Mr Glenn Swan  
Senior Development Manager  
Huntlee Pty Limited  
1 TRITON BOULEVARD  
NORTH ROTHBURY 2335  
4 May 2022

**Huntlee - Stage 1 Development (MP10\_0137-Mod-20)**  
**Response to Submissions Report**

## **ATTACHMENT A – RESPONSE TO SUBMISSIONS AND REQUEST FOR INFORMATION**

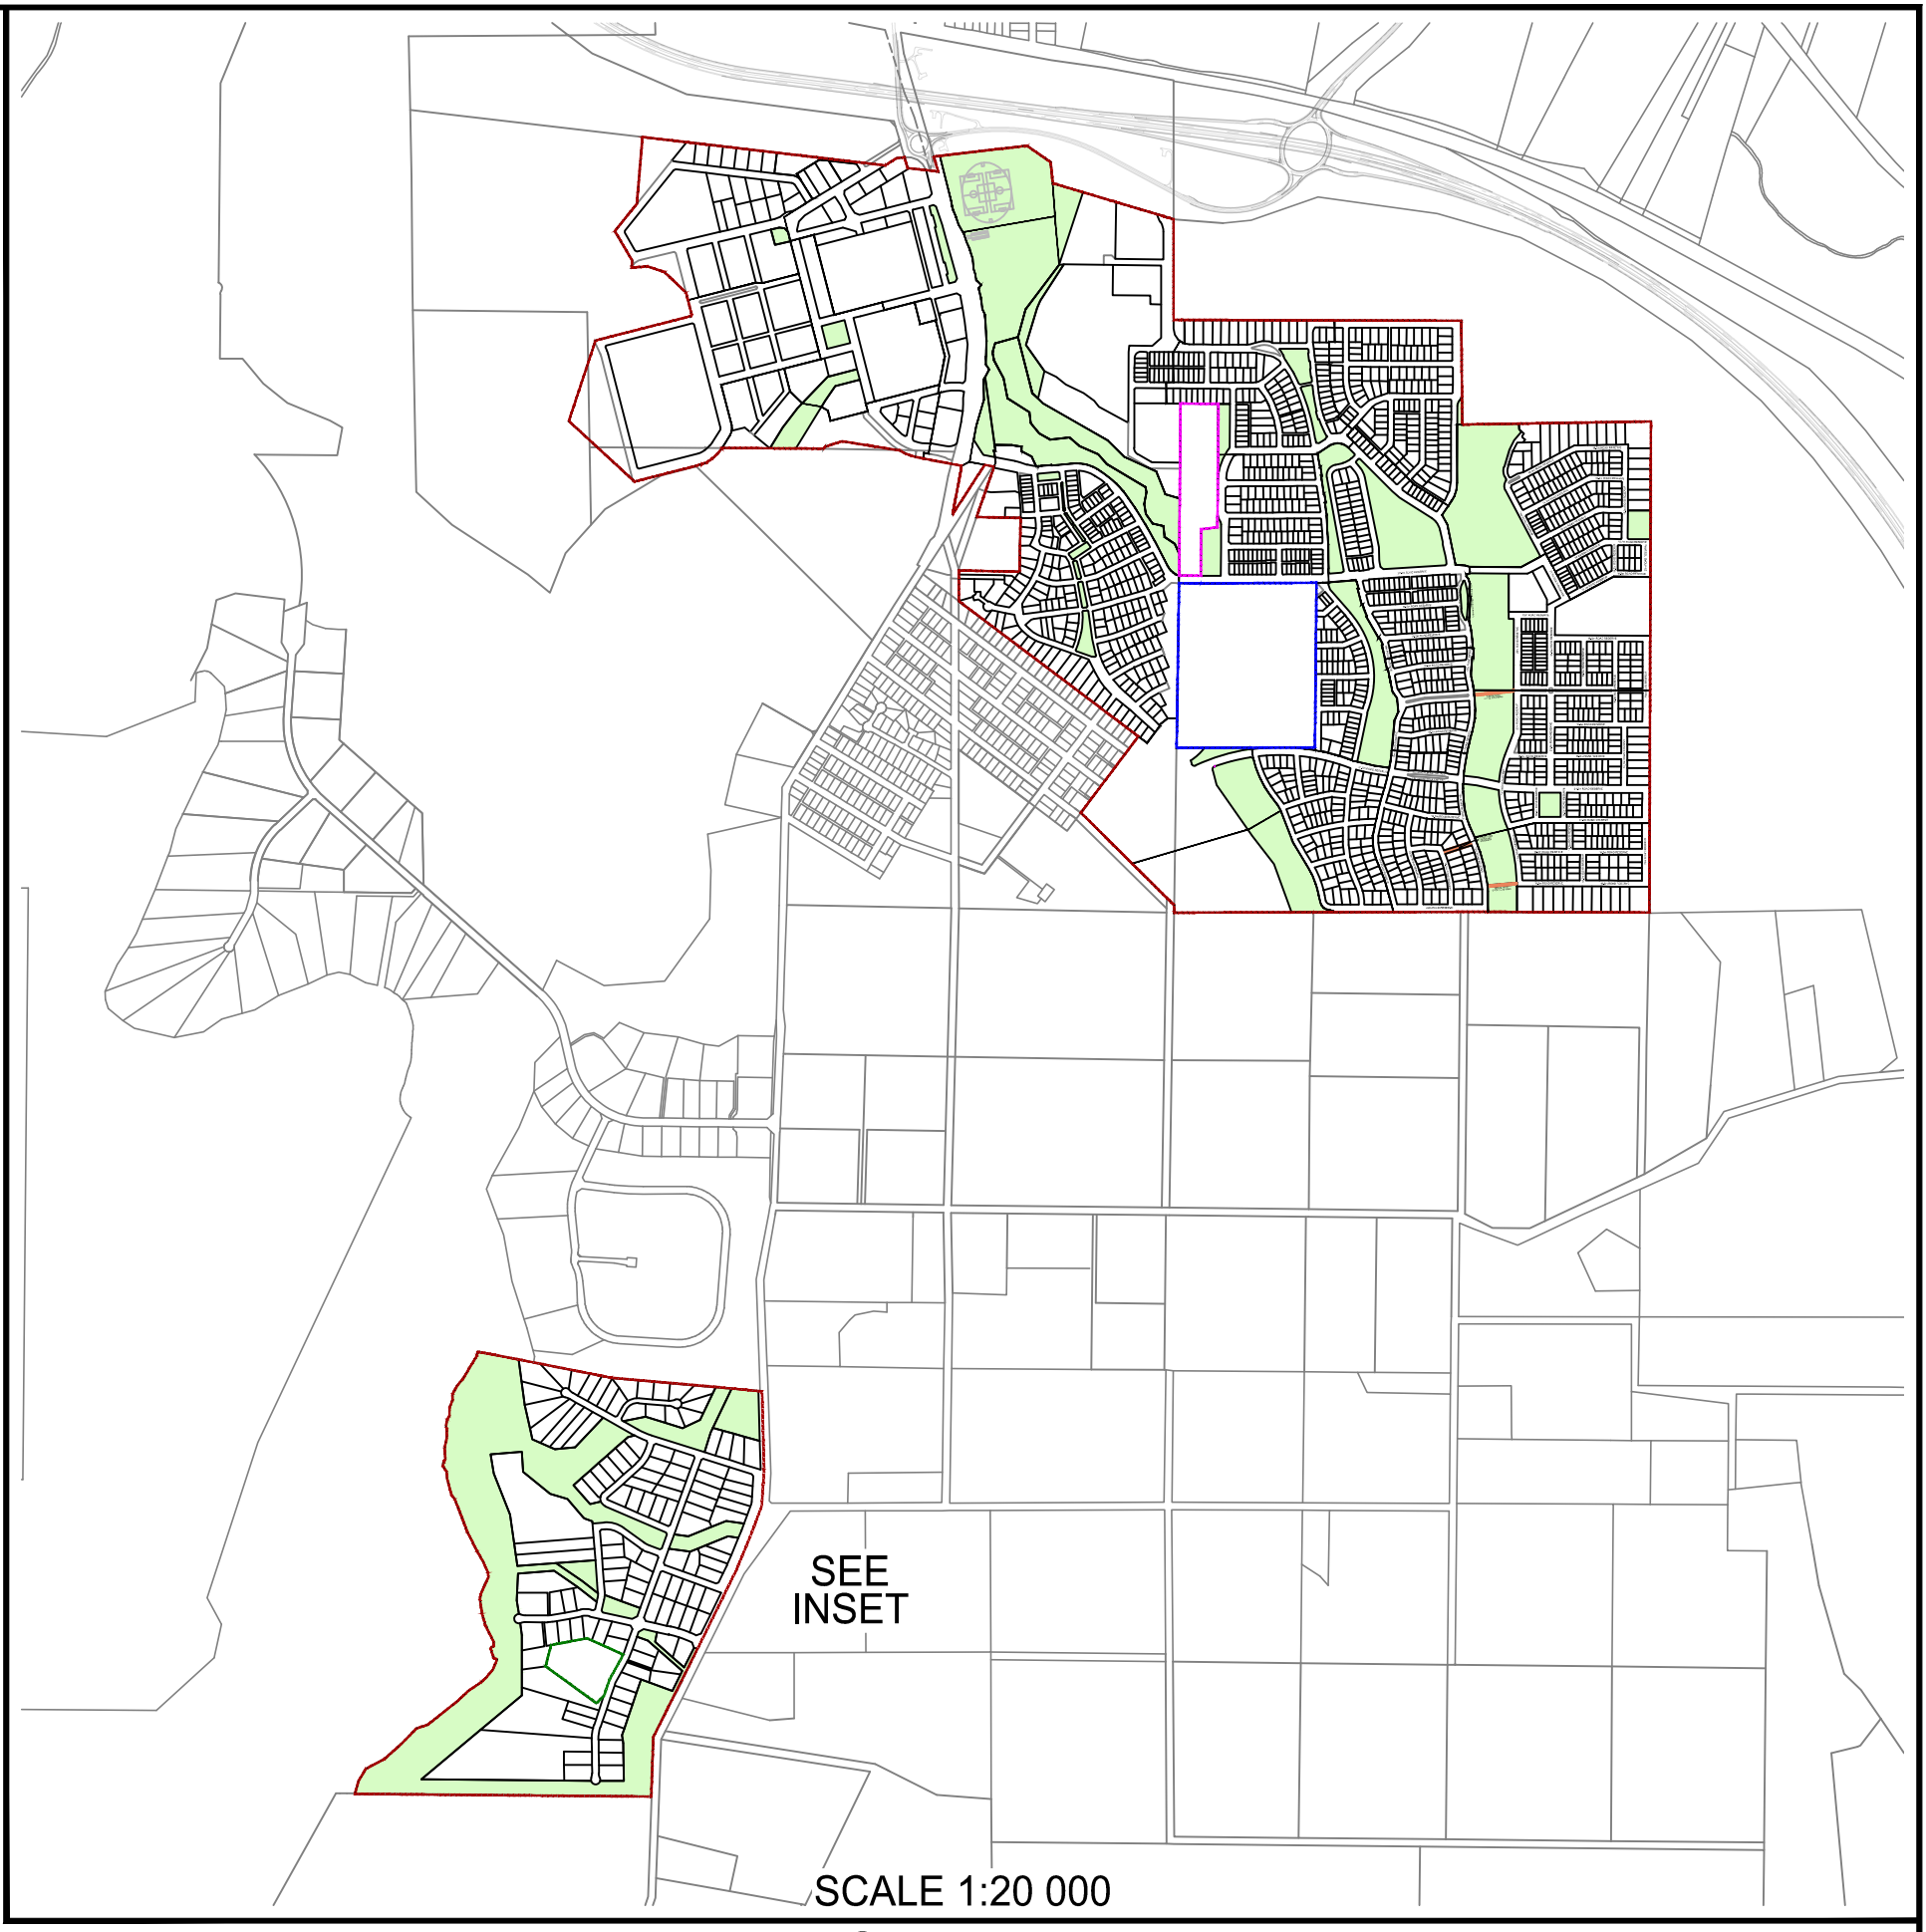
The modified layout of Substage 13 seeks to remove opportunities for future road connections to Lot 34 DP 755211, and introduce small areas of open space. The Department questions the usability of these areas of open space being narrow in width and recommends that the modified layout of Substage 13 be reconsidered.

In addition, the Department recommends you seek Bushfire Protection advice from an accredited Bush Fire Consultant for Substage 13 to allow for a cohesive subdivision pattern to be established across the subject site and Lot 34 DP 755211 and remove the need for the additional open space which Cessnock Council are not supportive of maintaining.
